# Rezoning Transportation Analysis

Petition Number: Insert Zoning Petition #2022-018

Revision Log:	Date	Description
	06-23-22	First Review (PDM)

OEHLER PROPERTY
CHARLOTTE - MECKLENBURG COUNTY - NORTH CAROLINA
CONCEPTUAL REZONING SITE PLAN

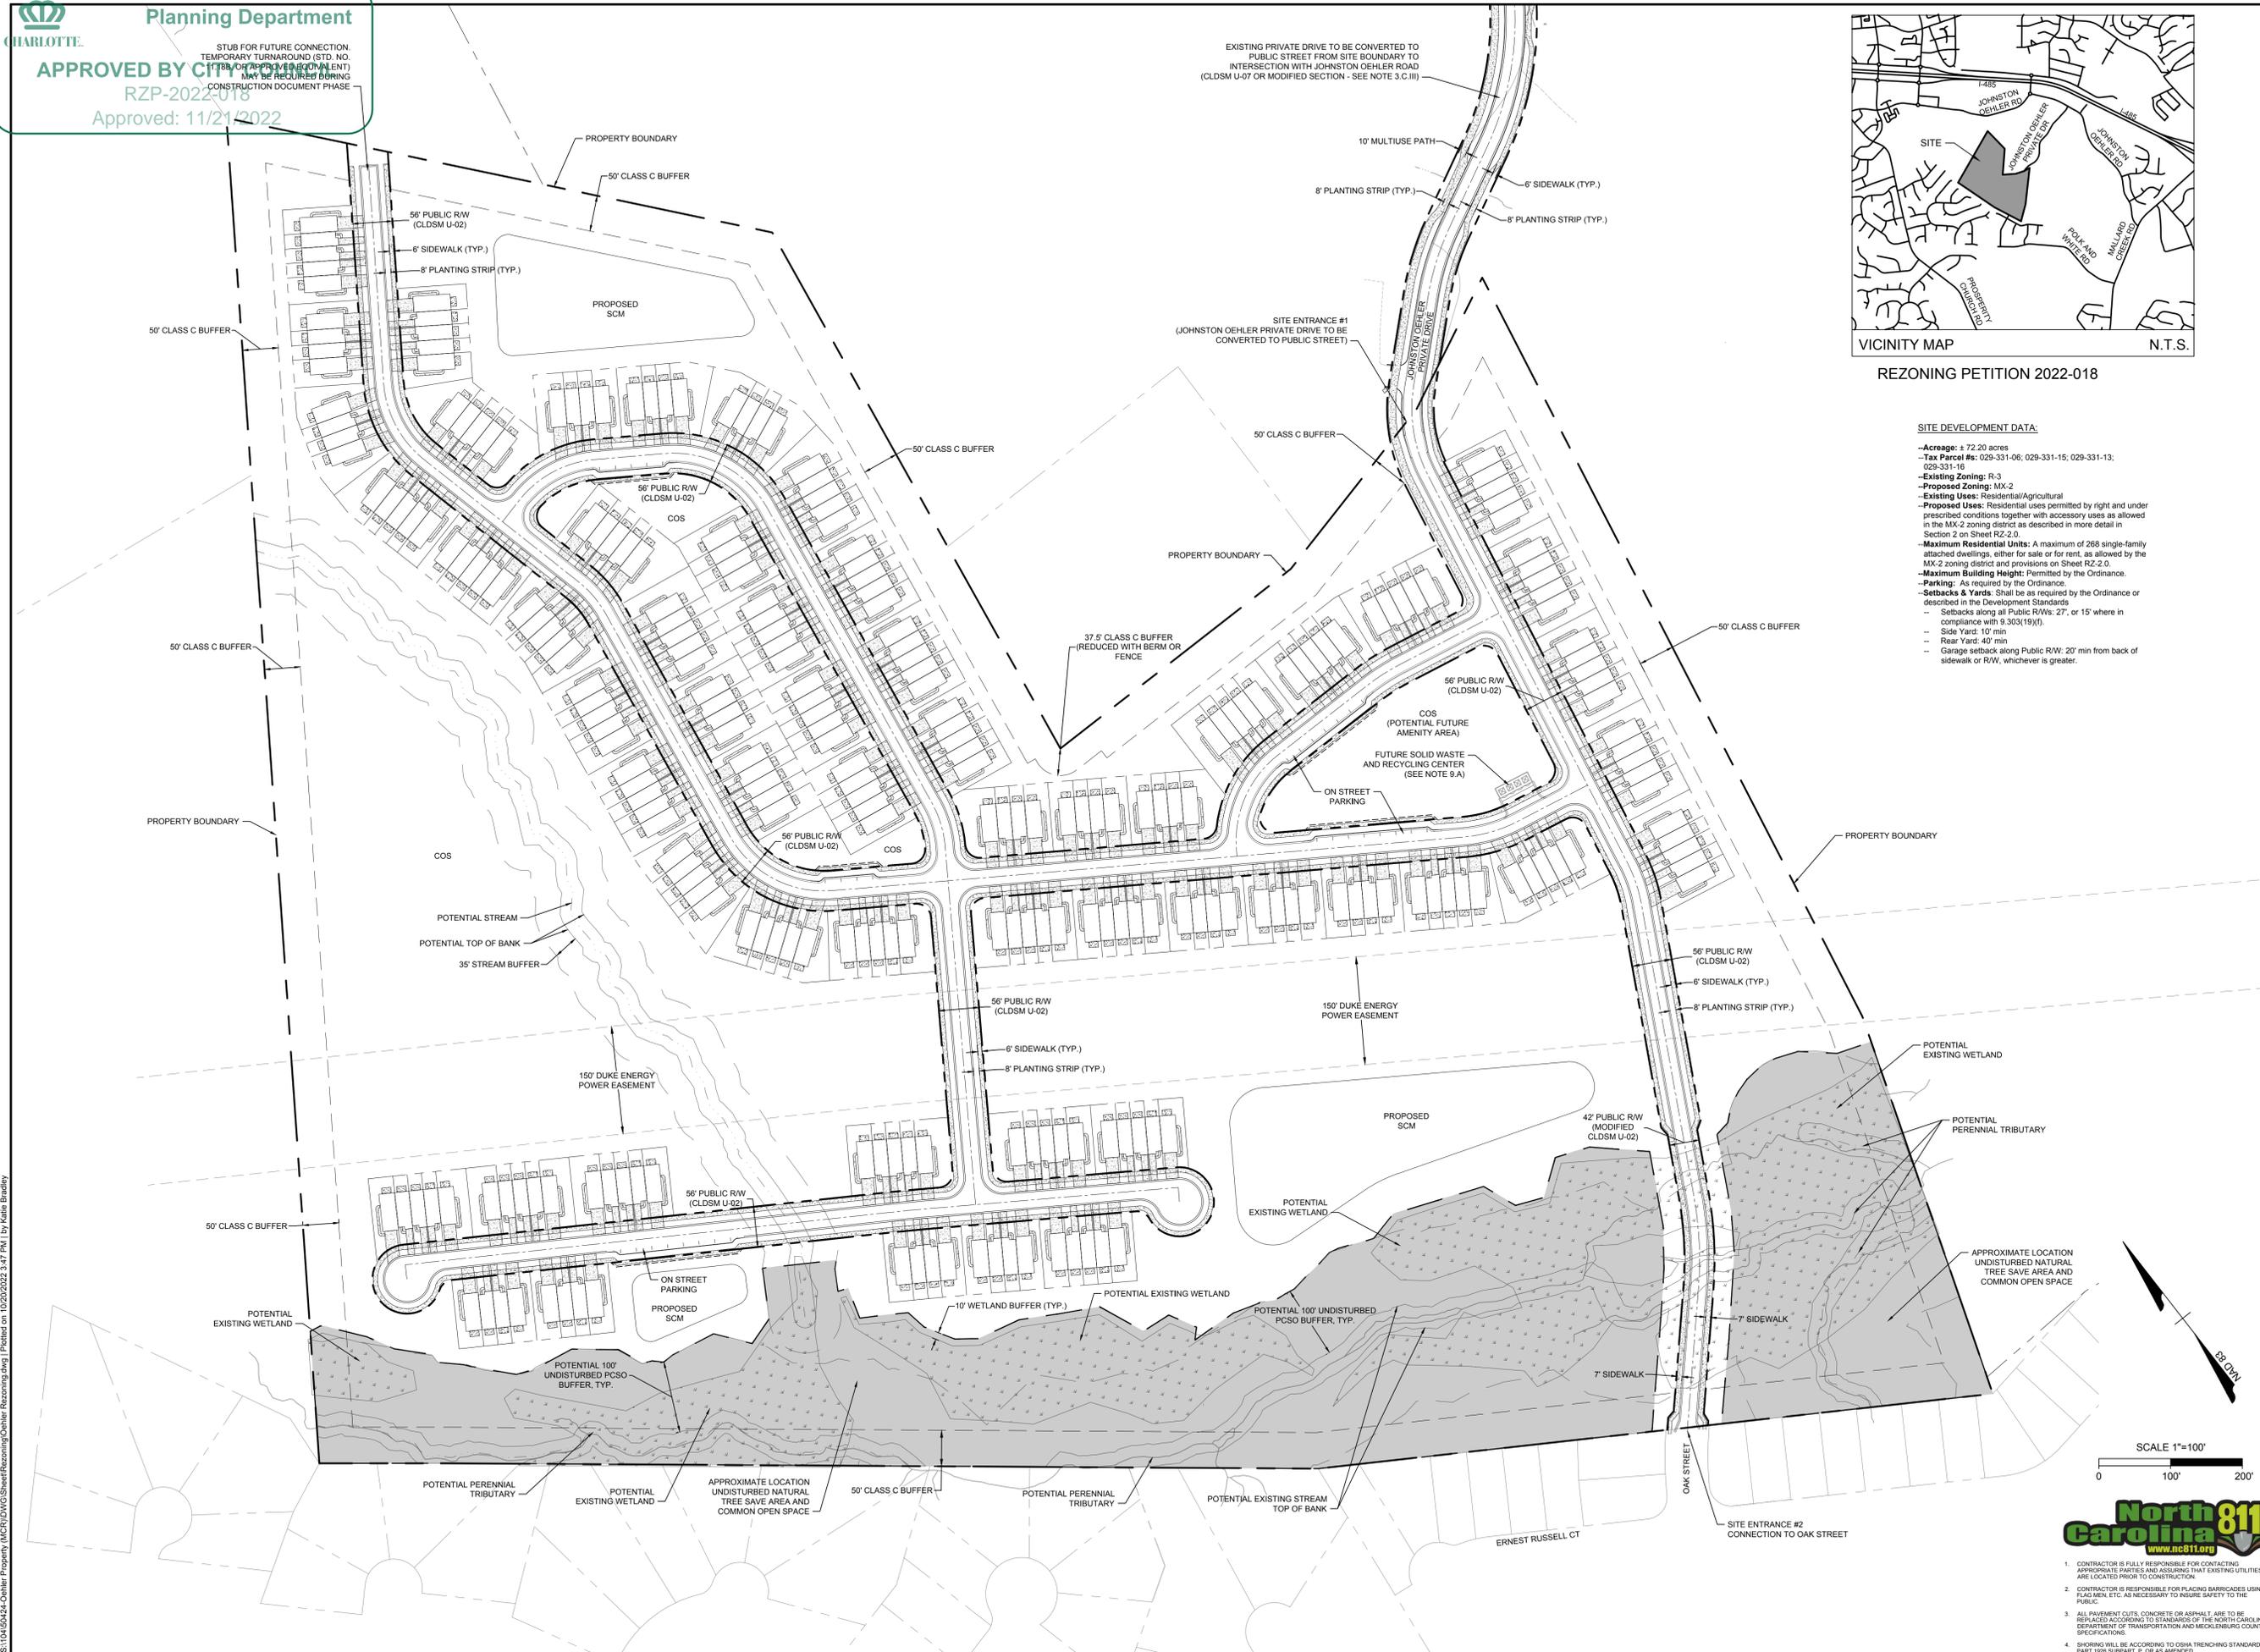
2. Revise site plan and conditional note(s) to identify the proposed streets and public or private. In addition, label each proposed street typical section per the CLDSM standard number on the site plan.
3. If the proposed roads will be public, revise site plan and conditional notes to commit to installing the Oak Street connection south of the site.
4. If the proposed roads will be public, revise site plan and conditional notes to commit to installing all required improvements on Johnston Oehler Private Drive identified by the Charlotte Street Acceptance Committee to bring the roadway up to public street standards.
5. Revise site plan to label and dimension the right-of-way of all proposed public streets.

6. Revise site plan to stub the proposed street to the property line and install a temporary turnaround per CLDSM 11.18B.

7. Revise site plan to remove on-street parking at the proposed horizontal roadway curves.

8. Revise site plan and conditional note(s) to commit to construct an 8-foot planting strip, and 6-foot sidewalk on all public roads per Chapter 20. The site plan shall label and dimension both items from the back of curb and gutter and road centerline.
9. A site plan note(s) specifying dedication and fee simple conveyance of all rights-of-way to the City before the site's first building certificate of occupancy is issued as needed. CDOT requests rights-of-way set at 2' behind back of sidewalk where feasible.
